Ribble Valley Borough Council  
By email

**Your ref:** 3/2021/0275  
**Our ref:** DC/21/1403v7  
**Date:** 09-JUN-22

**Location: Land behind the Dog Inn Market Place Longridge PR3 3RR**  
**Proposal: Proposed erection of 9 new dwellings and associated works**

Planning Application  
Proposed Site Plan

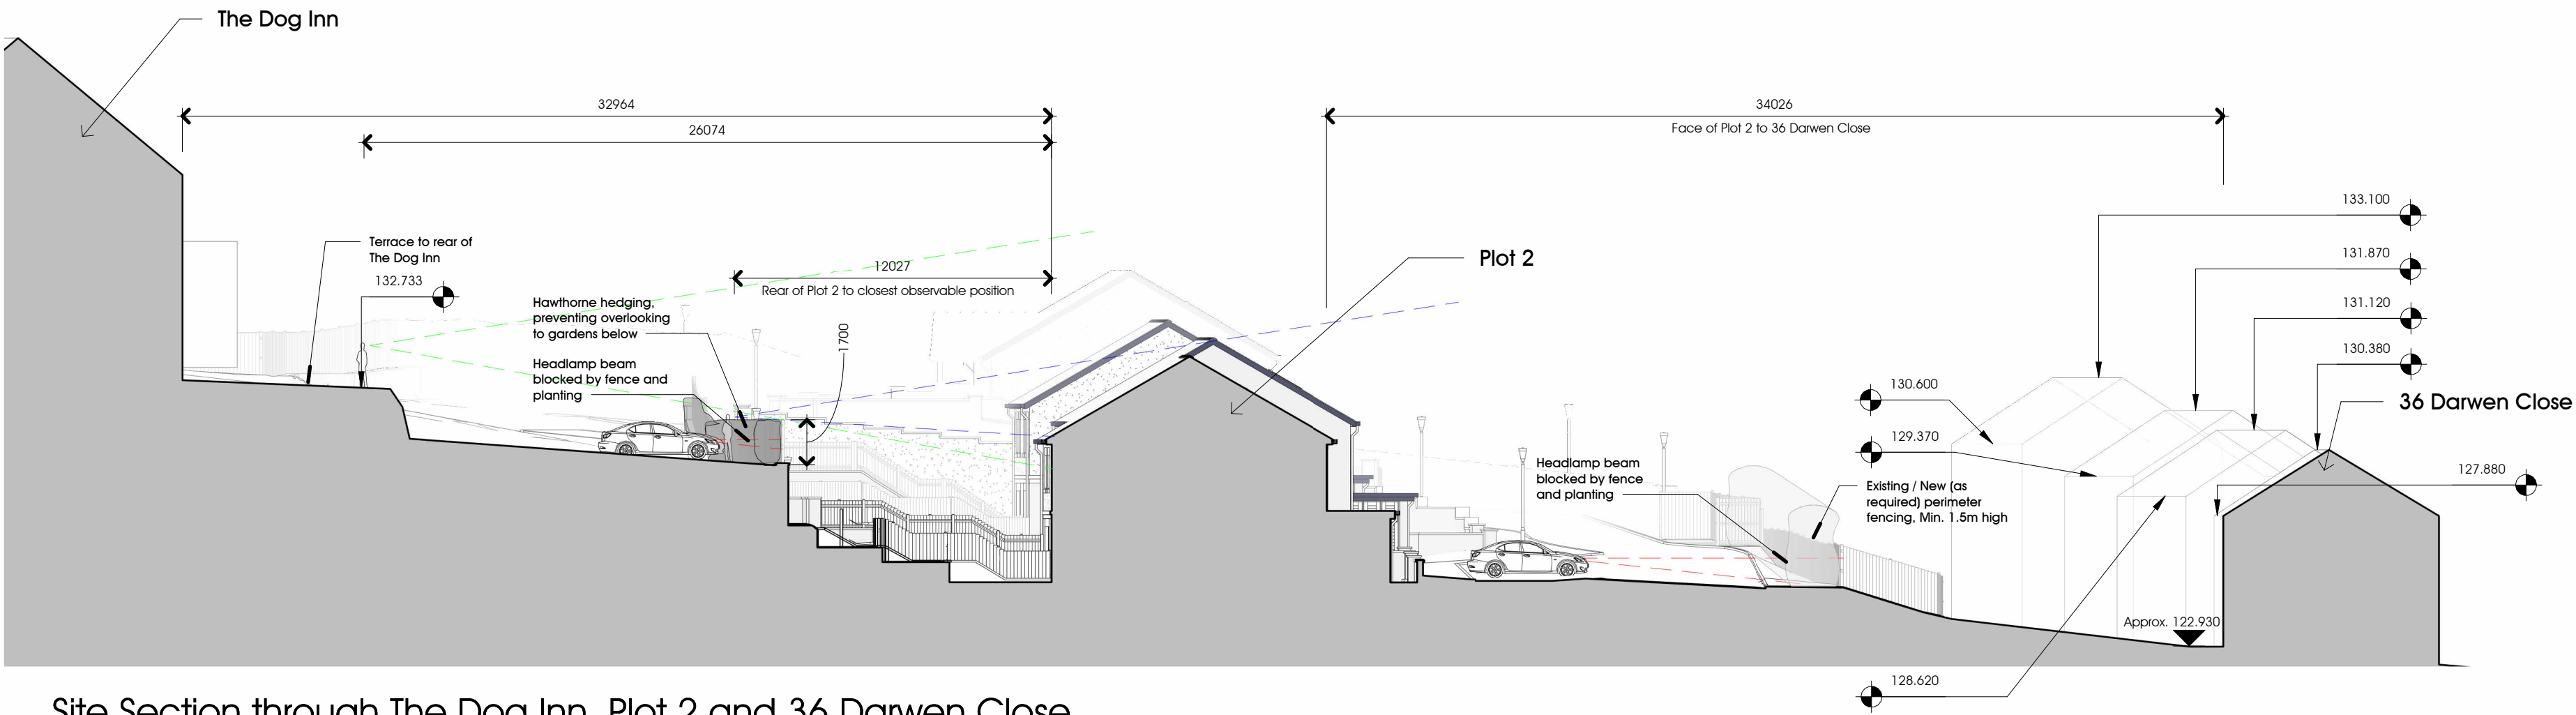
**A public sewer crosses the site and we may not permit building over it.** We require an access strip for maintenance or replacement. The minimum distances that might be acceptable to United Utilities are detailed within Part H of the Building Regulations however, we recommend the applicant determines the precise location, size, depth and condition of the pipeline as this is likely to influence the required stand-off distance from any structure.

JOB NO 3156  
DRAWING NO 120  
REVISION E  
SCALE 1 : 200 @ A1

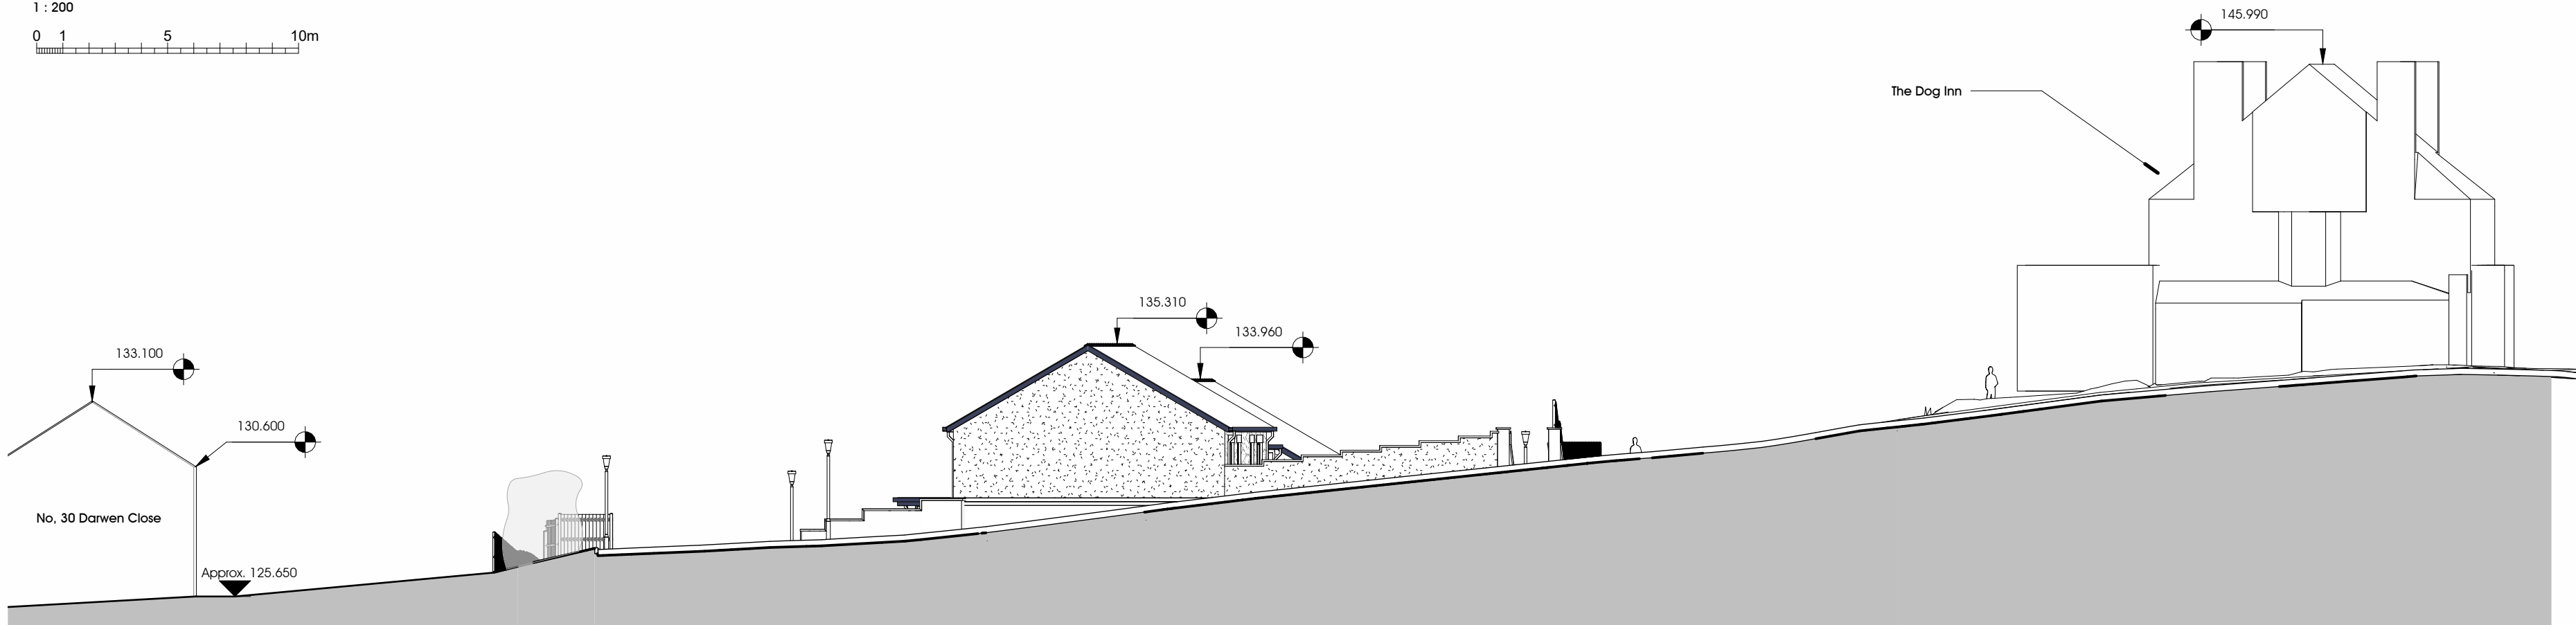
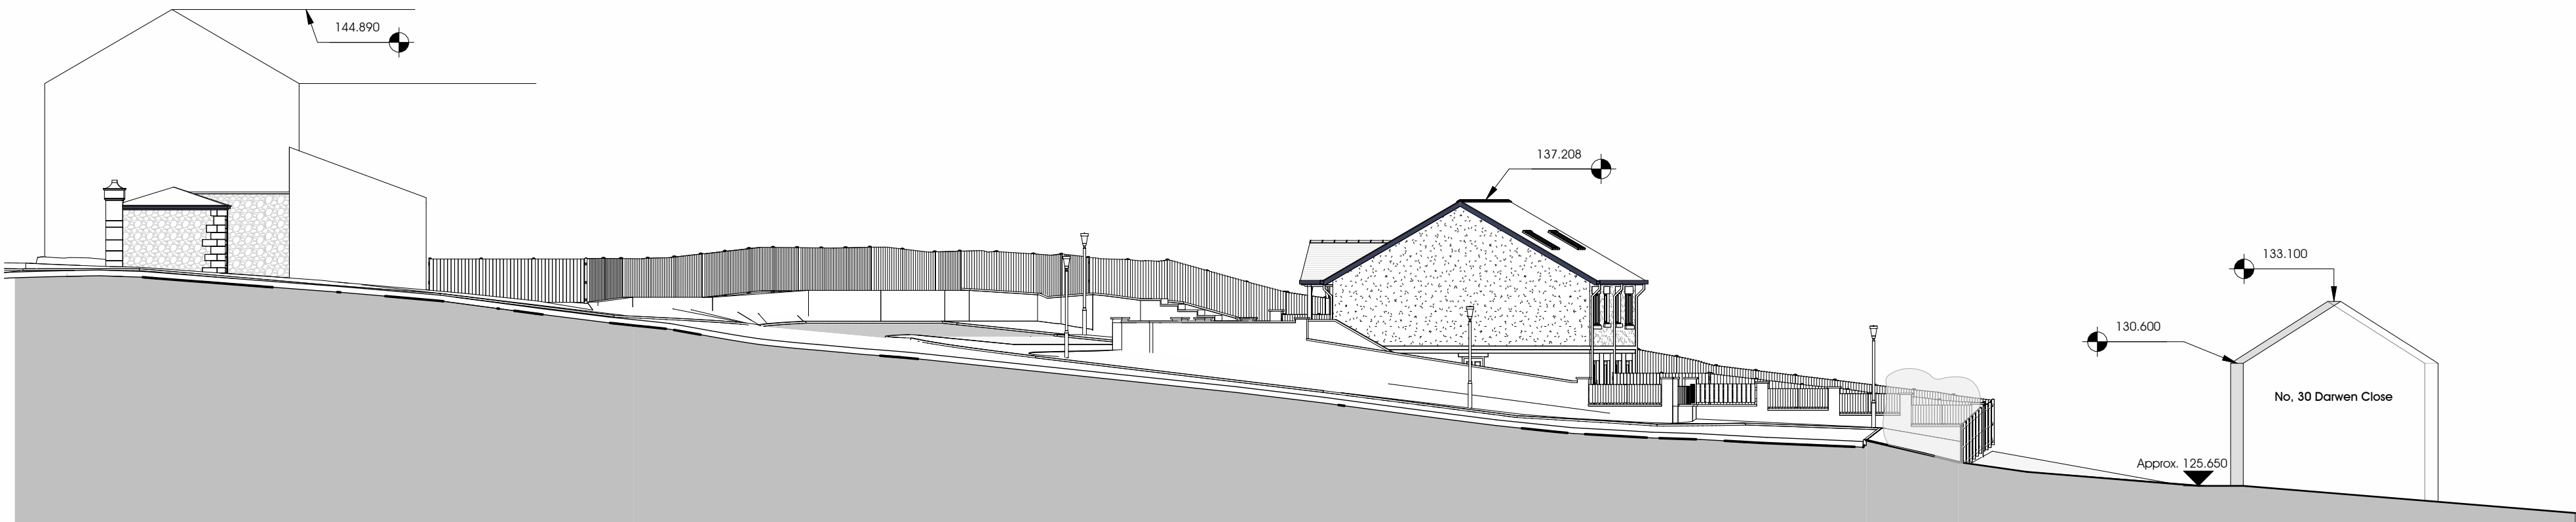
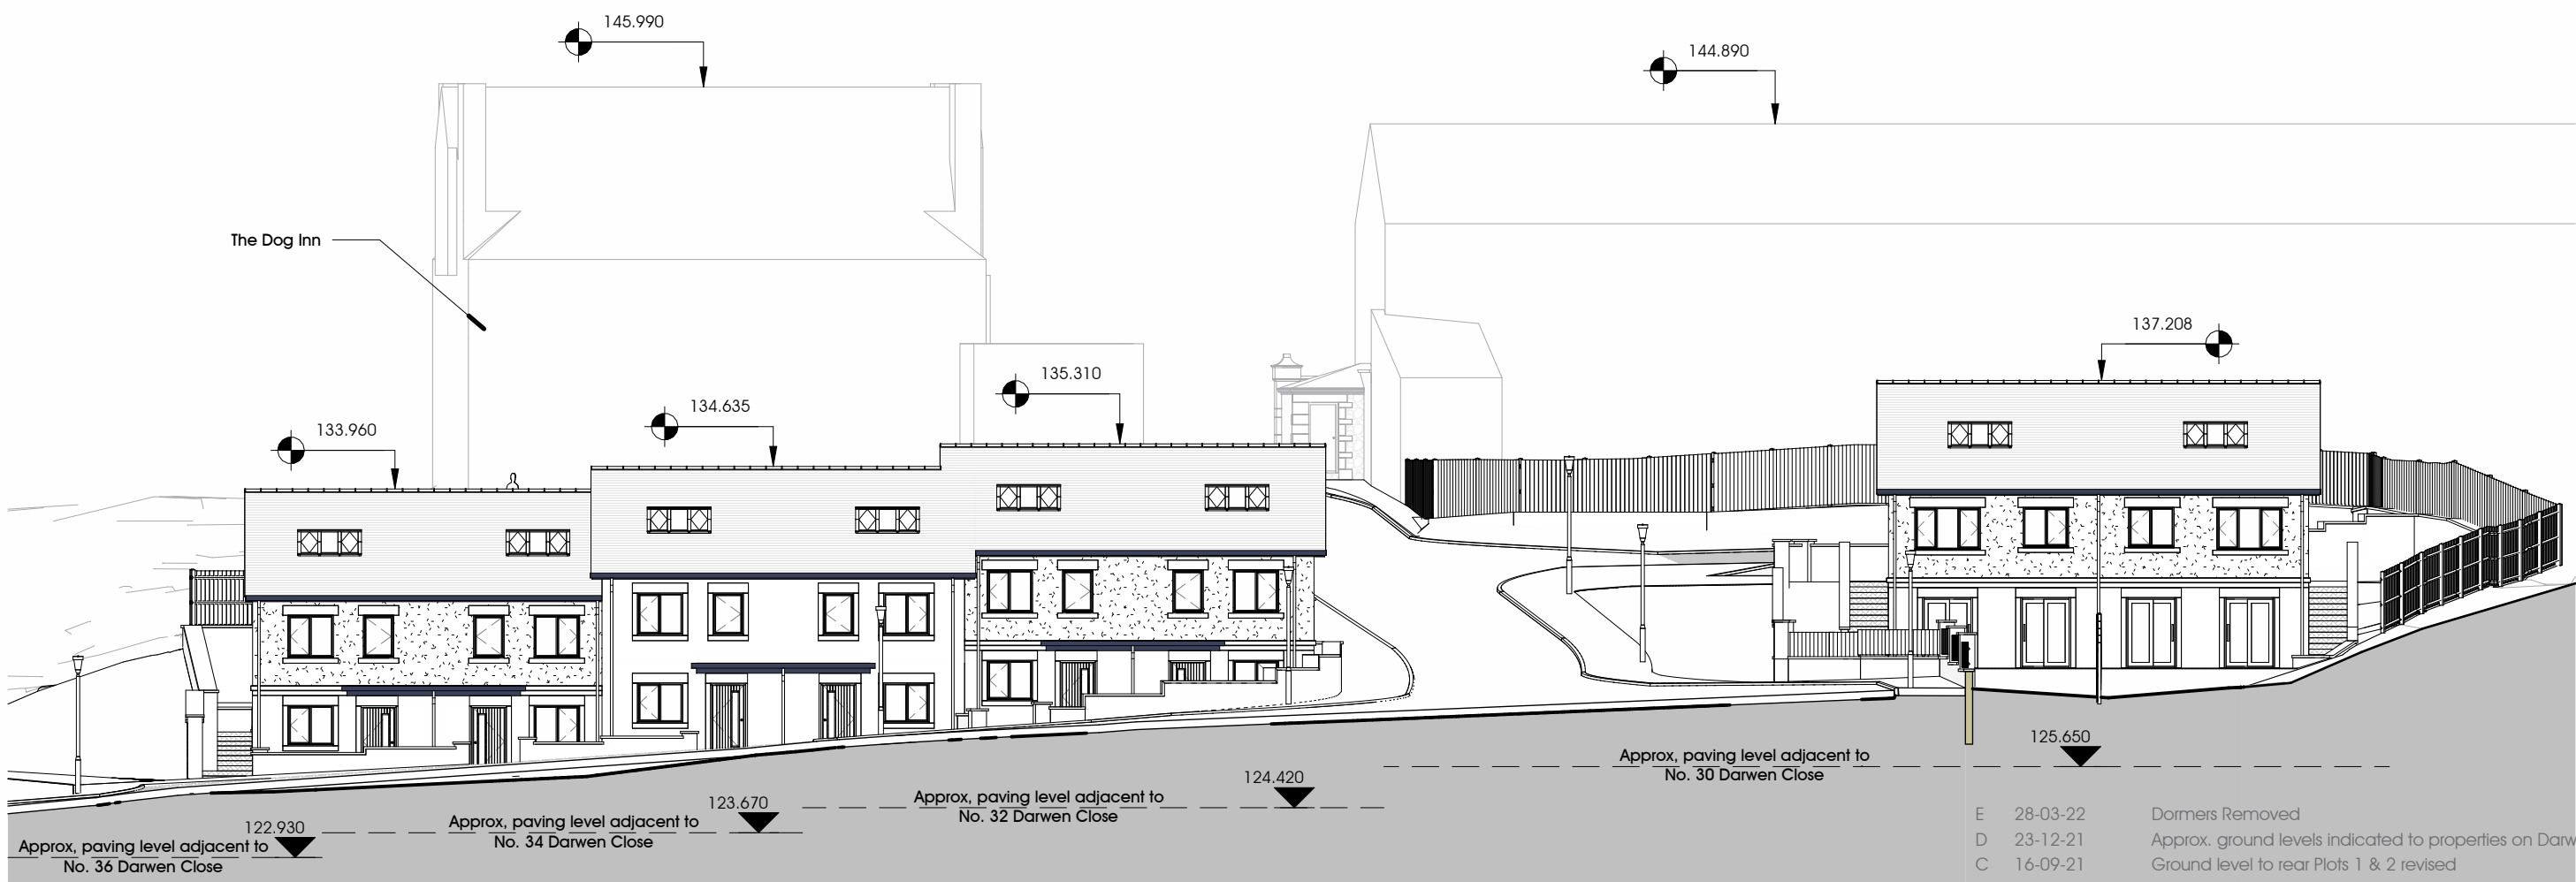
The proposed finished floor levels shown on the submitted plans are significantly lower than the predicted surcharge levels in the existing receiving sewer. The proposals could introduce a new low spot on the network which is an unacceptable risk. The proposed finished floor levels will therefore need to be revised and further information submitted for our consideration to address these concerns.

Our initial view is that comparing the proposed levels across the site against the existing surcharge levels in the sewer, we do not believe that the proposed diversion is feasible but we will await the findings of the modelling work before making our final decision. As referenced above, we request that the applicant engages with us on this matter as soon as possible.
